## Oakdale South SSD6917 MOD 8 – Response to Submissions – November 2018

Figure 3: 18-540-SKC001[A] (Source at&I 2018)

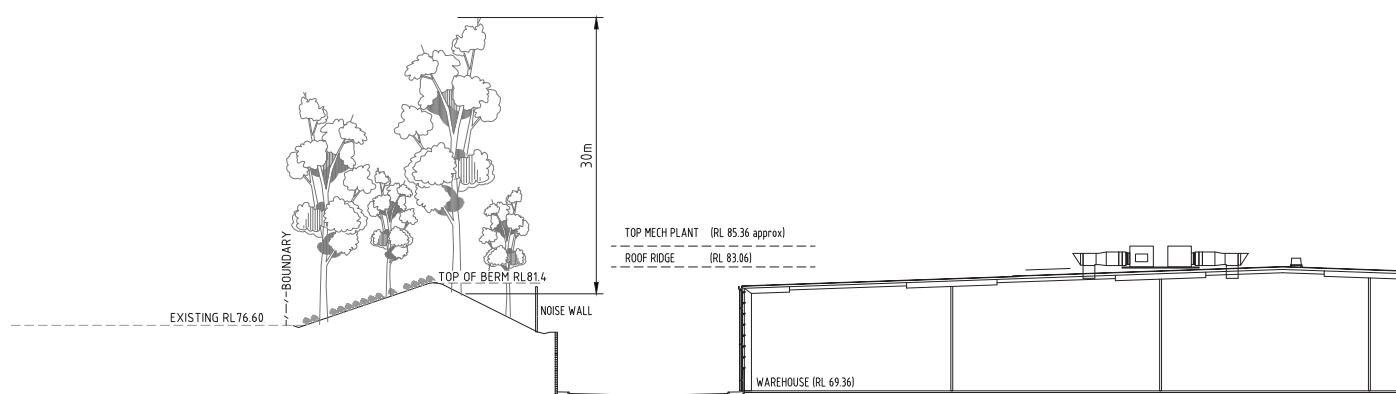
| <p><b>3.2 Goodman letter</b></p> <p>Figure 2 in the letter from Goodman dated 28 August 2018, submitted with the Modification Application, is stated to be the view of Precinct 5 from the south, including the landscape berm. The letter goes on to state that Figure 2 and 3 demonstrate that the visual impact arising from the rooftop plant is acceptable. The same Figure 2 is included in the e8urban Letter and is correctly labelled in that letter as the 'View 06 photo-montage' prepared by e8urban in 2016. Figure 2 therefore does not include the proposed rooftop plant 2 metres above the height of the building, which is the subject of the Modification Application, and is not an accurate depiction of the visual impact of the rooftop plant. Jacfin is concerned that the inclusion of Figure 2 in the Modification Application letter and the commentary provided in relation to Figure 2 has the potential to mislead the public and, in particular, residents to the south of the Oakdale South site as to the visual impacts of the proposed rooftop plant and that this should be clarified by Goodman.</p>   | <p>Figure 2 in the Goodman letter of 28 August 2018 demonstrates that, due to the topography, the berm, and the landscaping, the roof top plant will be adequately screened particularly by the landscaping on the southern boundary. Goodman retains ownership of Lot 5 and is responsible for its maintenance and management along with the rest of the Oakdale South Estate. As with all Goodman assets, there is strict landscape maintenance programme in place to ensure the estate presents as attractively as possible. This is extremely important to the Goodman brand. The boundary landscape treatment will therefore be carefully maintained on an ongoing basis pursuant to Condition E61 of SSD6917. The boundary landscaping provides full range screening through both low-level shrub and tree planting. This landscaping has already been established and will continue to develop over time.</p> <p>E8Urban have confirmed that the roof top units will not protrude above the landscaping (refer to sections, <b>Appendix B &amp; C</b>) on either the southern or eastern boundaries and that the additional visual impact resulting from the units is acceptable, particularly when viewed in context with the approved height and scale of the host warehouse building. As above the proposed units penetrating above the maximum 15m roof height only applies to a minor 0.4% of the total roof area and only by approximately 1.3m. Both Figure 2 and the section provided in Figure 3 assists to demonstrates this.</p> |

| <p><i>Finally, the Modification Application letter states that the application will not increase the perception of bulk and height. It is difficult to accept this assertion in circumstances where the application materials indicate that the rooftop plant will protrude approximately 2 metres above the ridge line assessed in the 2016 VIA.</i></p>   | <p>As discussed above there are only 4 rooftop units proposed to extend above the ridgeline along the entire 260m of building length, and only approximately 1.3m above the 15m limit, at the tallest point. Only 0.4% of the total roof area will include plant which will protrude above the currently approved 15m height limit. The units are therefore considered to be relatively fine elements and recessive when considered against the bulk and scale of the approved warehouse, and do not therefore have unacceptable visual impacts on the surrounds.</p>  |
